City of Albuquerque Stormwater Construction Site Inspection Report

ESC File No.	C17E128	Project Name:	Starbucks - Alameda
NPDES Id. No.	NMR1003KD	Location:	8721 Washington St. NE
5/8/2023	Owner	Contractor	
Operator	Fair Plaza Associates		
Contact name & title	Sean McMullan		
e-mail	sean@mcmullanrealestate.com		
Contact Phone #	505-821-1662 C 259-6223		
COA Inspector	Doug Hughes	Start/End Time:	11am
Construction Phase:	Starbucks is open, site is inactive, stabilization complete		
Type of Inspection:	<input type="checkbox"/> Regular	<input type="checkbox"/> Storm Event	<input type="checkbox"/> Past Storm Event >0.25" <input type="checkbox"/> 311/Complaint <input type="checkbox"/> Follow Up
Weather at time of inspection?		clear	Temperature: ~ 70
Estimated date of last storm 0.25" or greater		3/16/2023

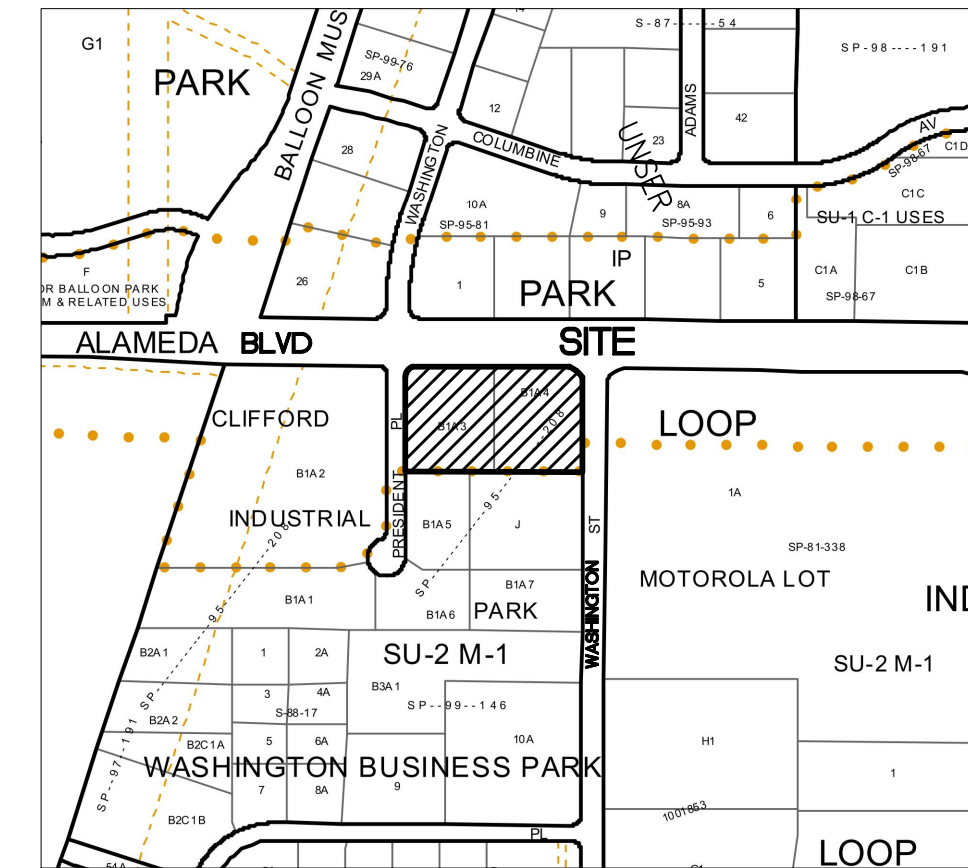
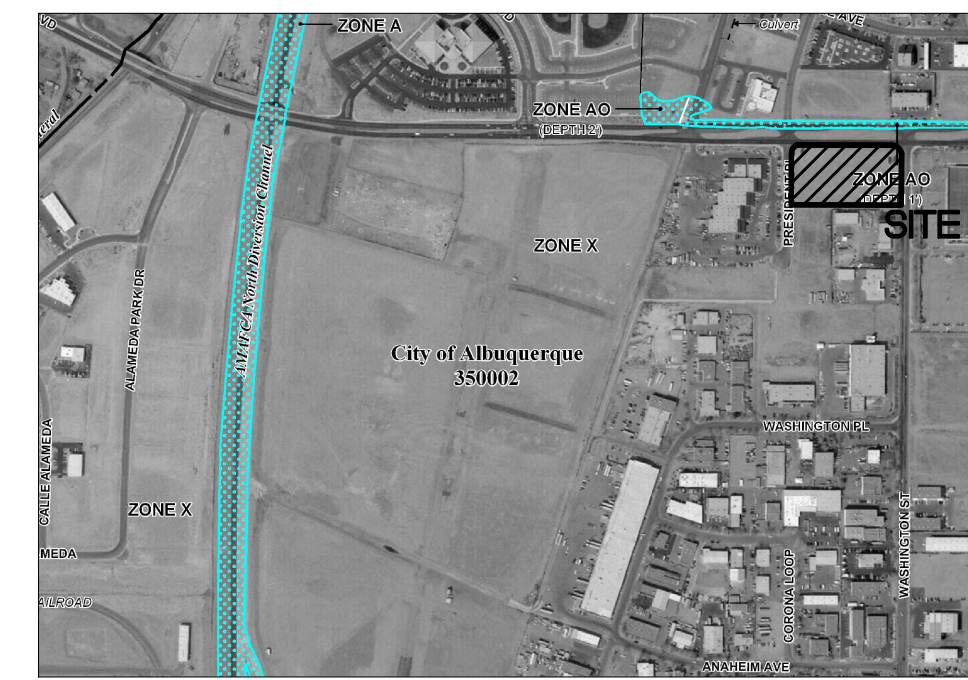
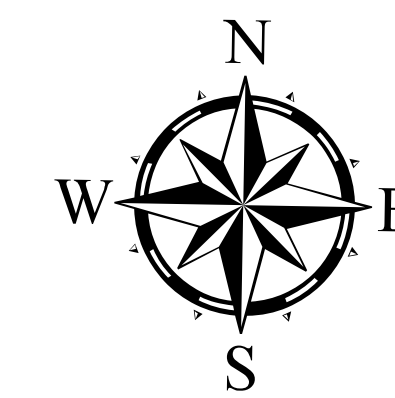
Item Number	Deficiency/ Corrective Action		
1	Coverage expired w/o terminating. Vegetation satisfies CGP 2.2.14.c so remove BMPs (silt fence) and position and terminate permit coverage per CGP part 8.		
2			
3			
4			
5			
2.1	Discharge off site? (Y/N)	yes	
4	Self Inspection Reports	missing	Latest report Date:
